The Planning Inspectorate
Yr Arolygiaeth Gynllunio

SCOPING OPINION:

Proposed Green Hill Solar Farm

Case Reference: EN010170

Drawing no.: P3535_LPR_ZZ_XX_DR_Z_Scoping_0171
 Coordinate system: British National Grid
 Scale: 1:10,000 @ A3

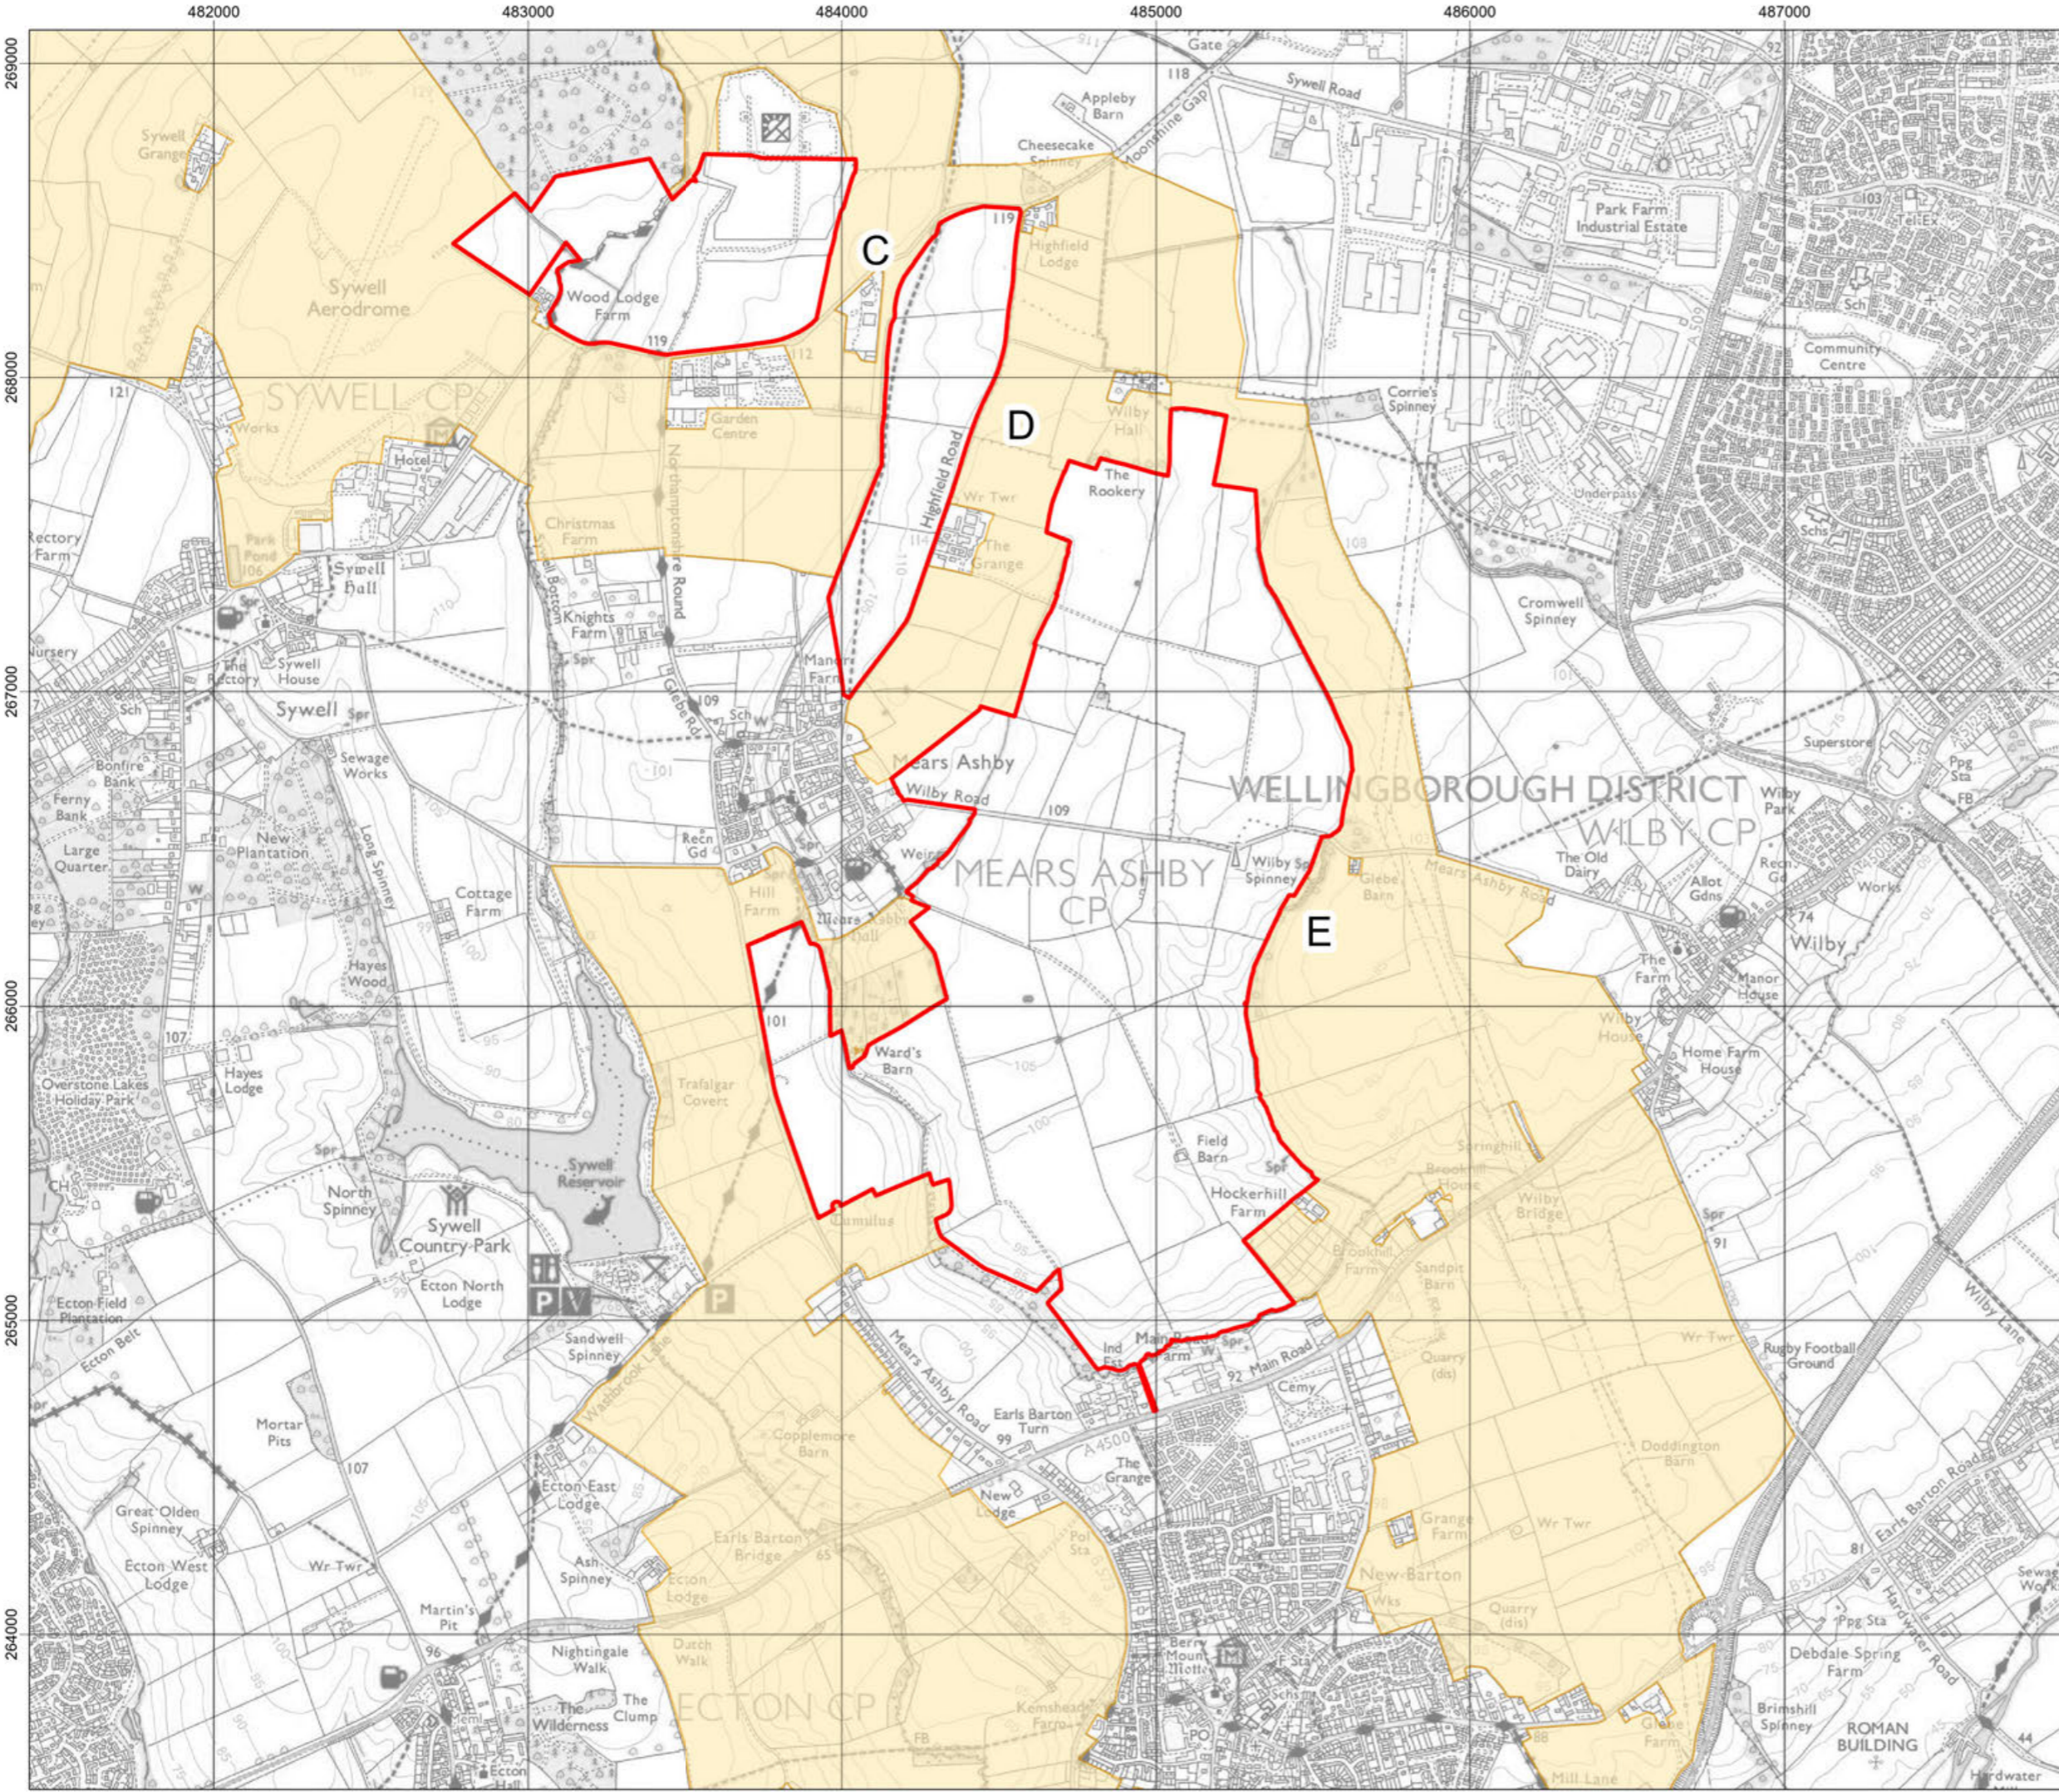
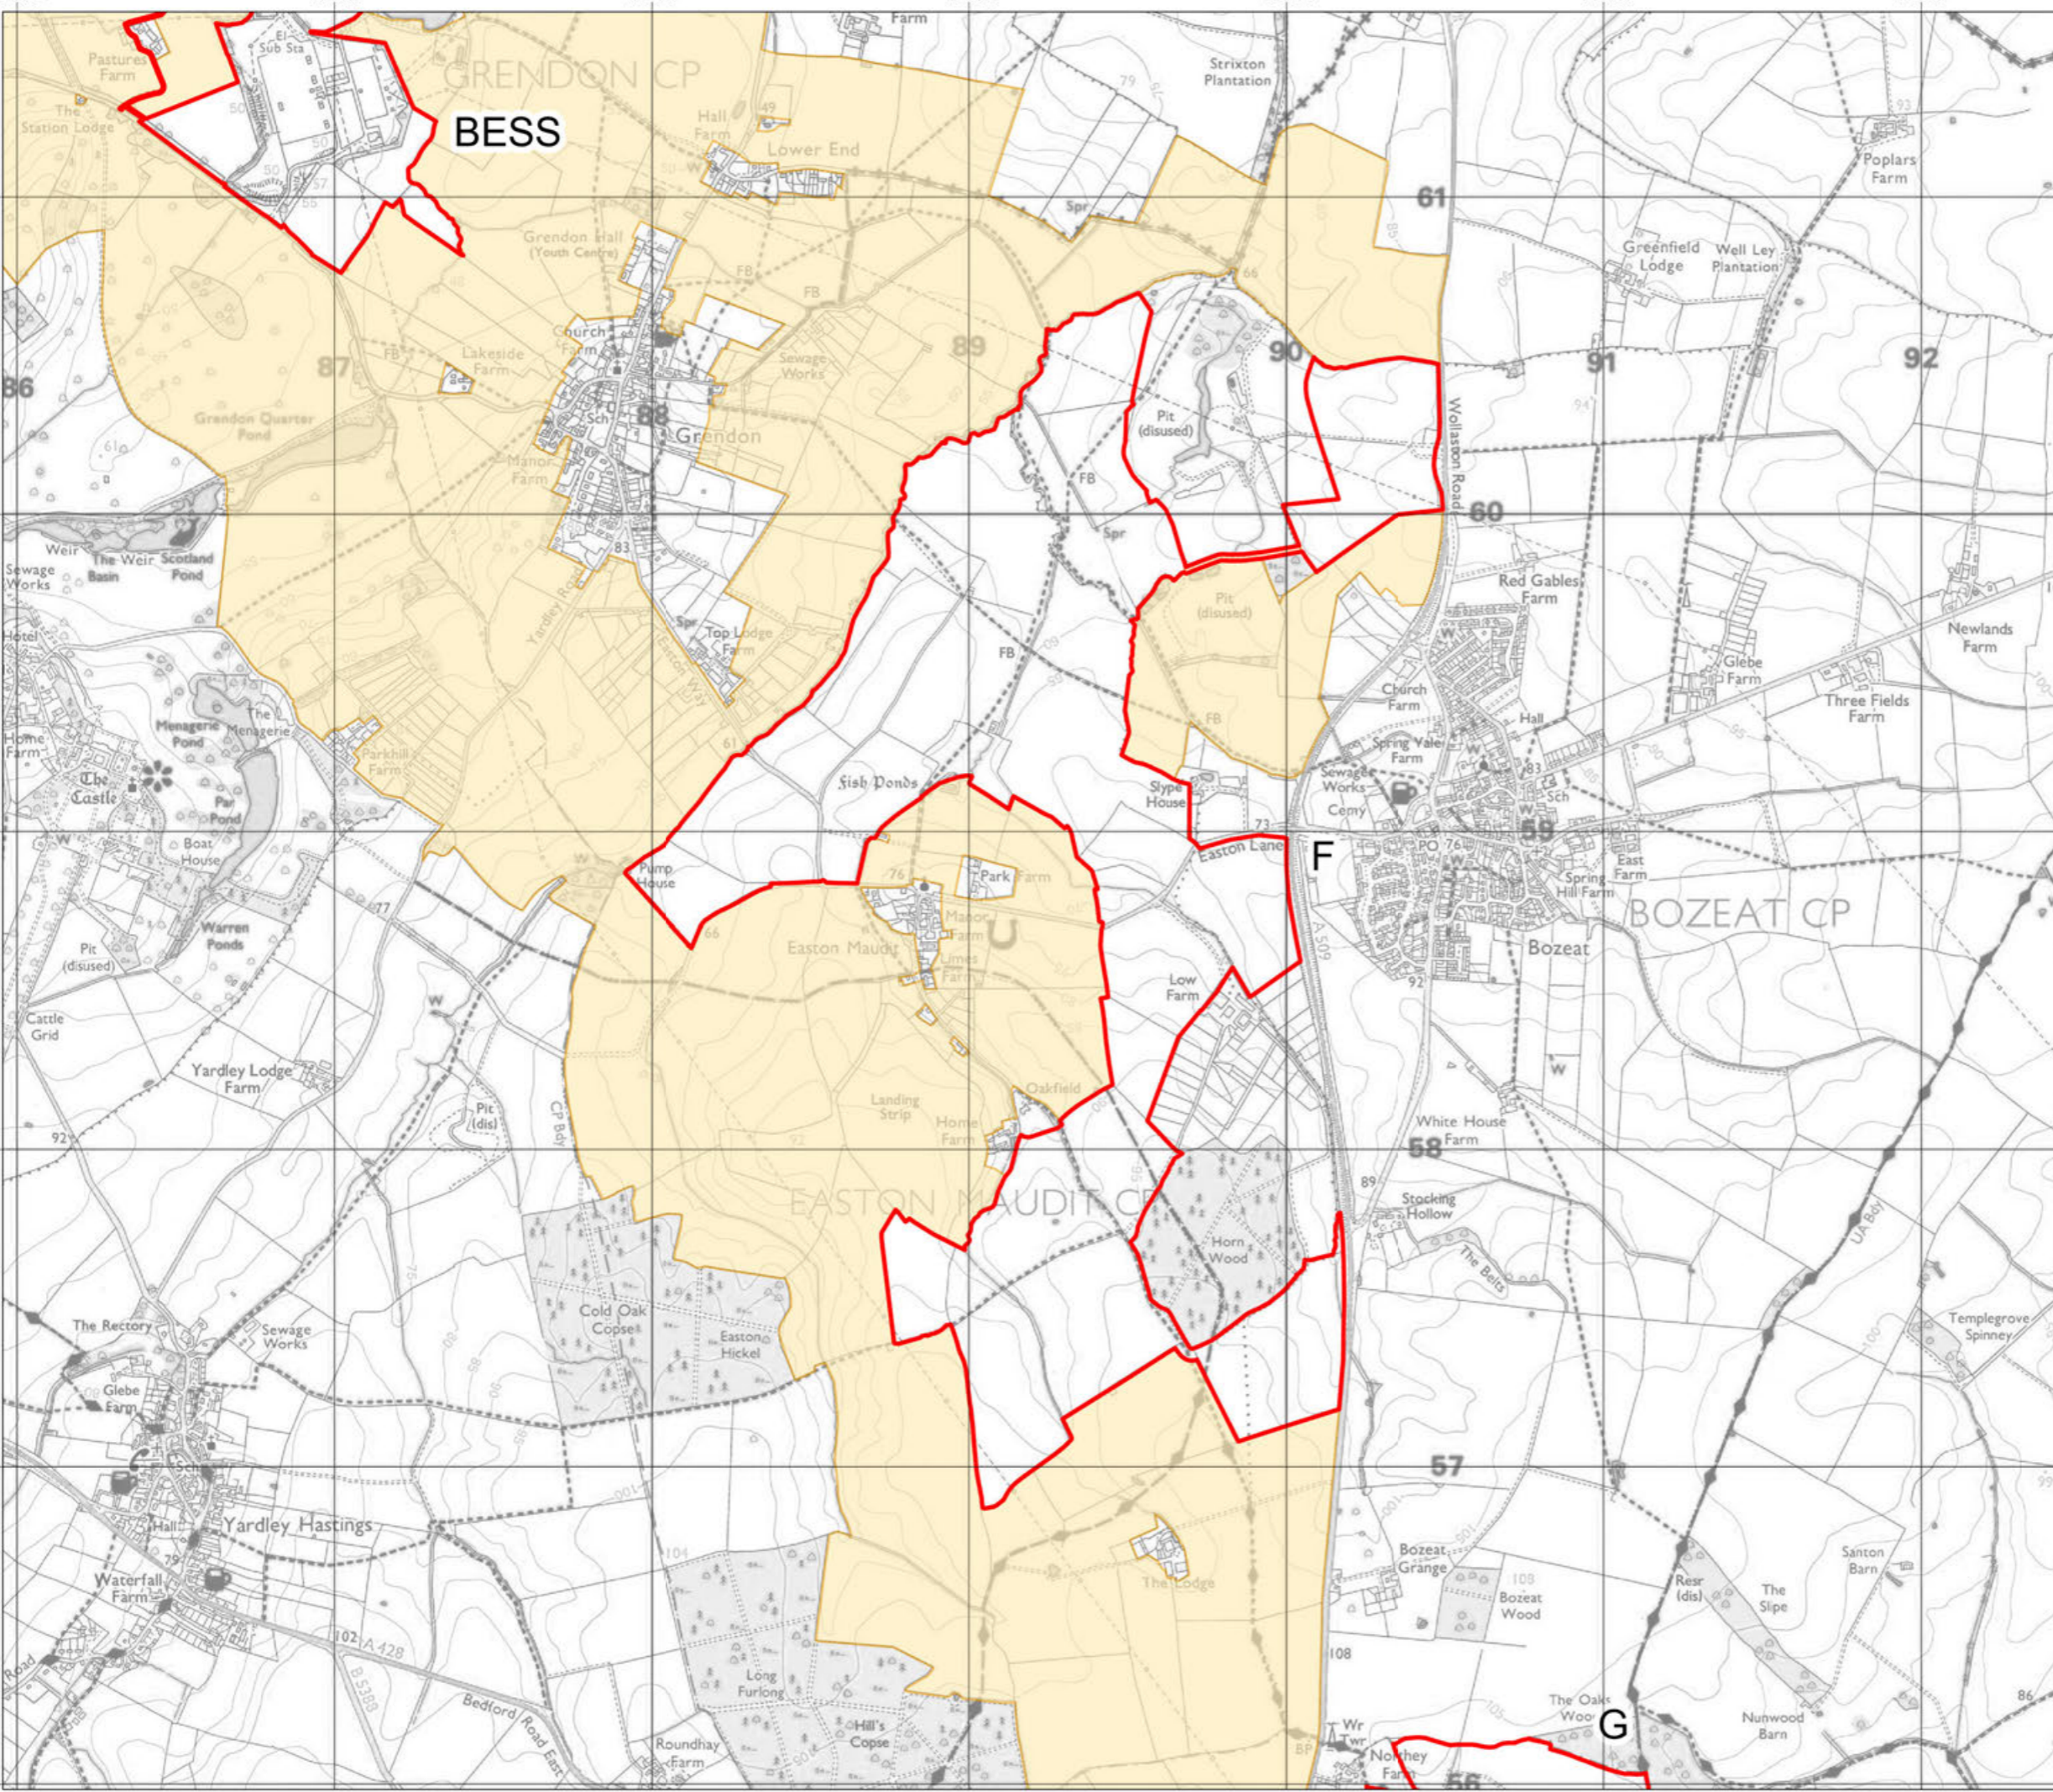
21.14		Figures – red line boundary	The Inspectorate notes that in figures provided the red line boundary denotes only the site areas that contain the solar panels and AD; and the Cable Route Search Area is hatched separately. The red line boundary depicted on the ES figures should encompass the entire application site, ie Sites A – G, the BESS site and the Cable Corridor.
